WEST SUSSEX COUNTY COUNCIL CONSULTATION

TO:	Arun District Council FAO: Mrs A Gardner
FROM:	WSCC - Highways Authority
DATE:	25 October 2019
LOCATION:	Springfield House Springfield Close Rustington BN16 2SZ
SUBJECT:	R/230/19/PL 1 No. dwelling with detached garage (part resubmission following R/91/17/PL & R/204/18/PL).
DATE OF SITE VISIT:	n/a
RECOMMENDATION:	Advice
S106 CONTRIBUTION TOTAL:	n/a

Job Title	Springfield House		
Client	Castle Property Developments		
Drawing Name	Garage - Plan & Elevations		
Drawing Status	Planning		
Drawn by	DF	Date	Sept 19
Checked by		Date	
Drawing Scale	1:50 & 1:100 at A1		
Drawing No	Status	Revision	
181303/	09

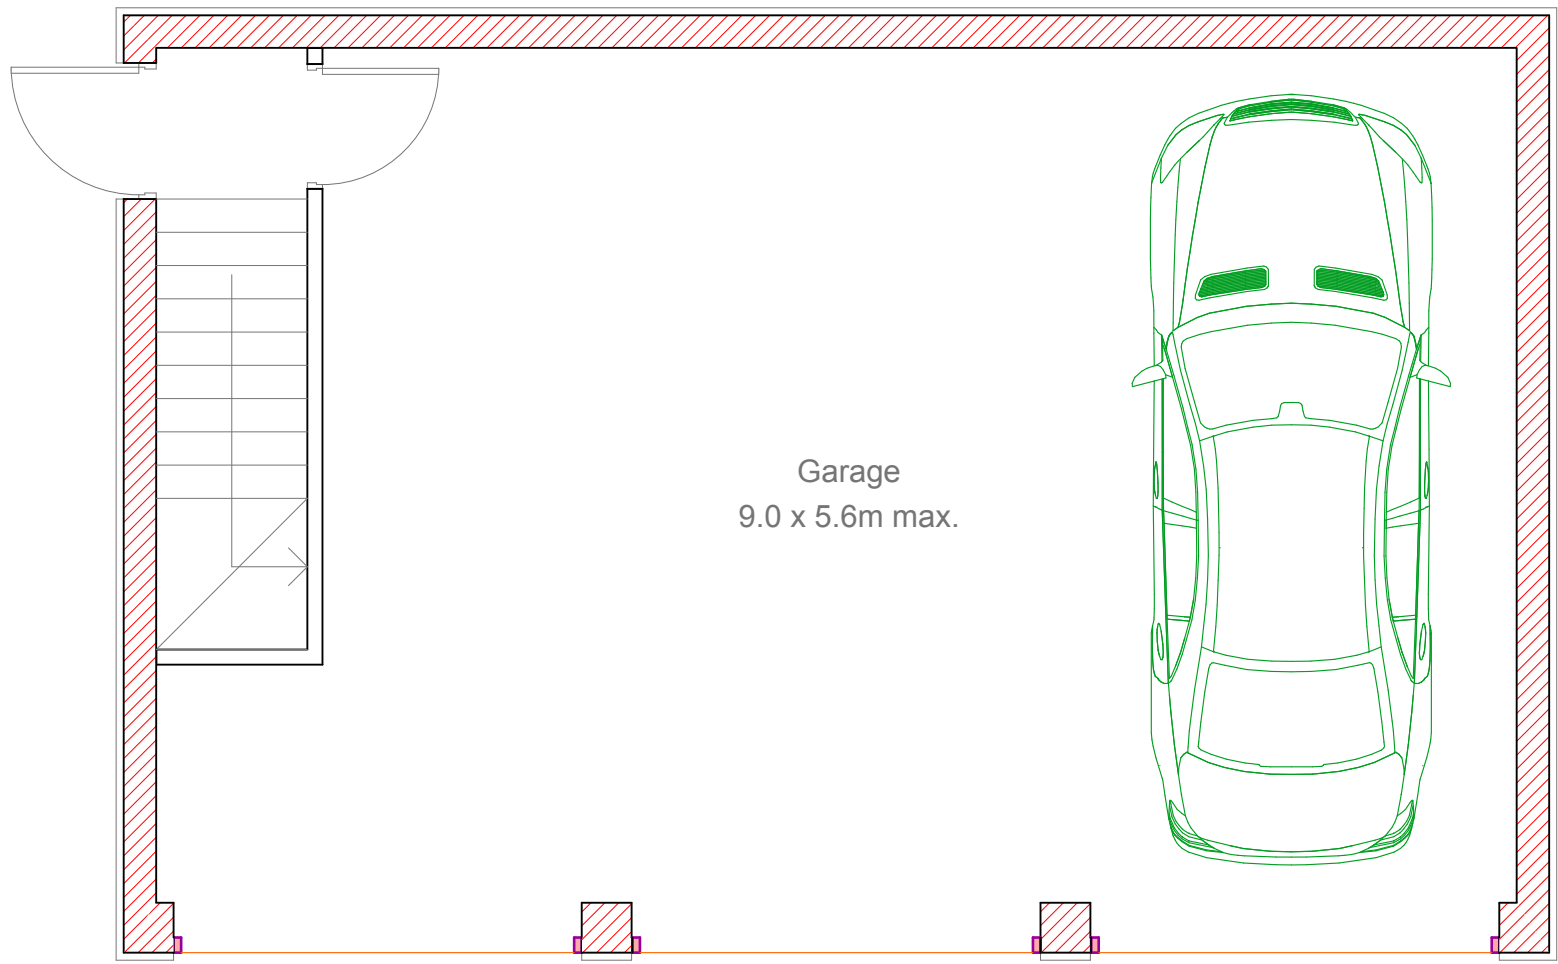
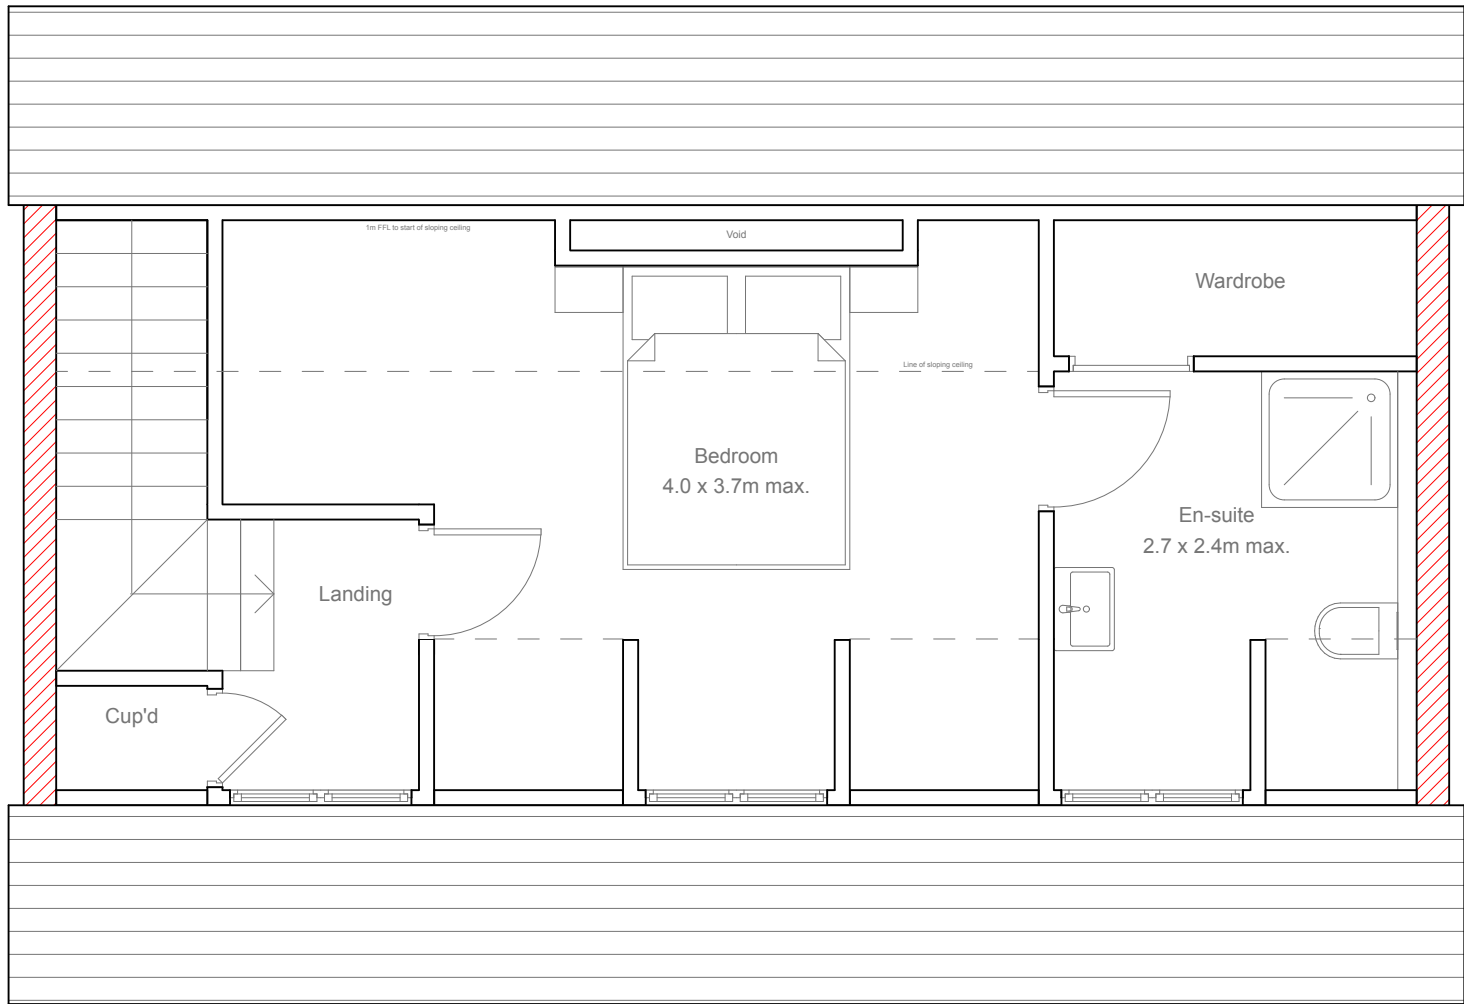
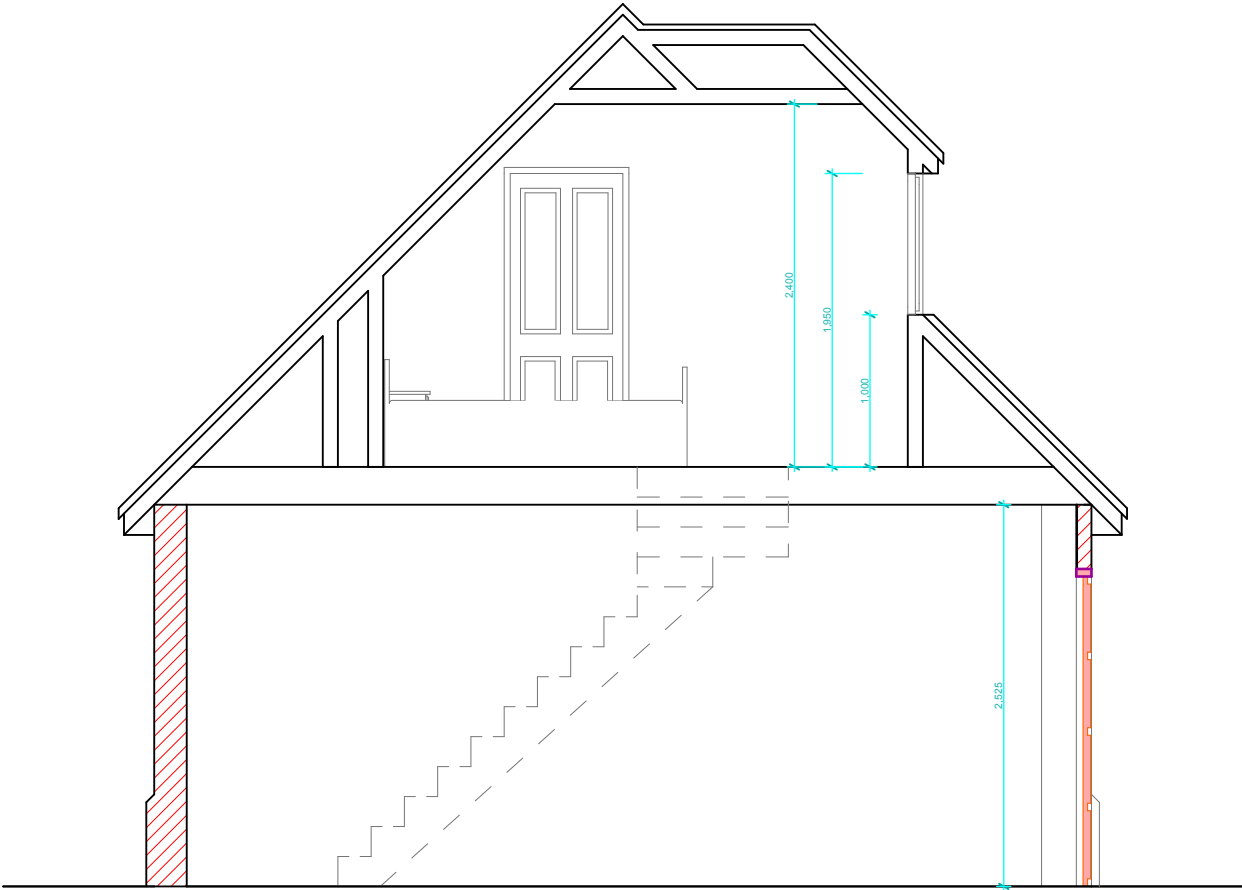
The garage will now be situated to the north-east side of the dwelling and upsized to accommodate 3 vehicles. The proposed garage has sufficient spaces to accommodate 3 vehicles and complies with Manual for Streets (MfS) standard for 3x6m per single garage. The hardstanding area adjacent to the garage has the sufficient space to accommodate the shown parking spaces for two vehicles.
